Lancashire Archaeological
Advisory Service

Your ref: 3/2016/0531

Planning Application 3/2016/0531: Retention and extension of unauthorised agricultural access track; Land adjacent to Gregsons Farm, Settle Road, Newsholme BB7 4JF

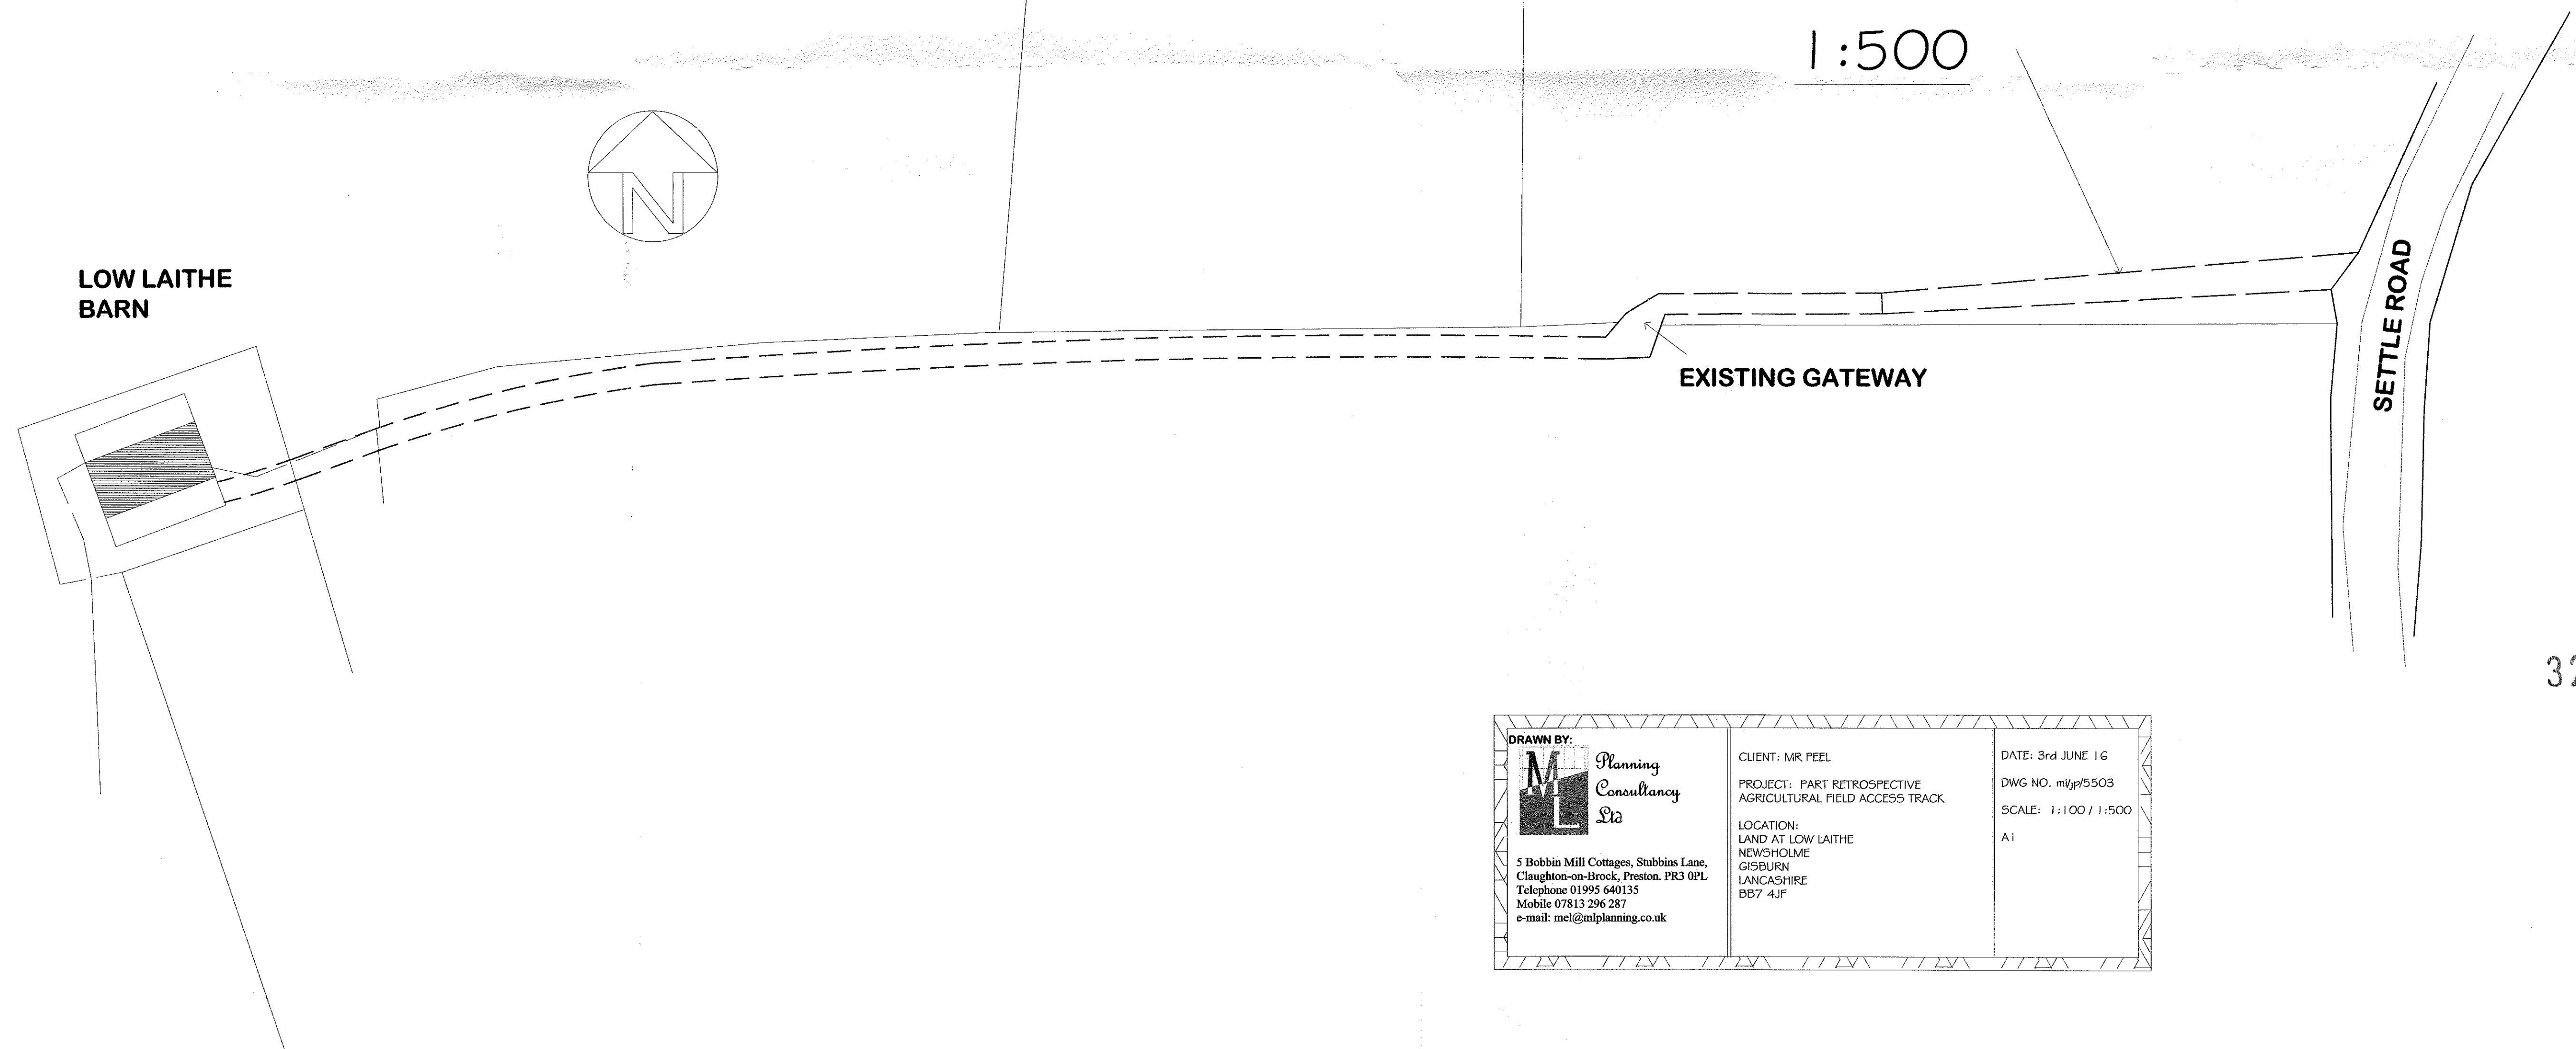
The track section that has already been constructed seems to follow the line of a track shown on the OS 1:10,560 mapping of 1853 (sheet Yorkshire 166, see attached) and later 1:2,500 county series mapping. This historic line appears to be an original access to Low Laithe but varies from that proposed in that it remains to the north of the field boundary rather than crossing it and continuing along its south side. It seems probable that the metalling encountered during the construction of the first part of the new track relates to the surfacing of the historic track, and could be expected to continue along the north side of the field boundary.

The proposed track would also appear to have only a limited impact on the undesignated heritage assets, and that would be concentrated in the area where the track deviates from the historic line to run south of the field boundary. Whilst it would be preferable for the new track to remain on the historic line, rather than the proposed shift to the south, we would not raise any fundamental objections to the route as currently proposed.
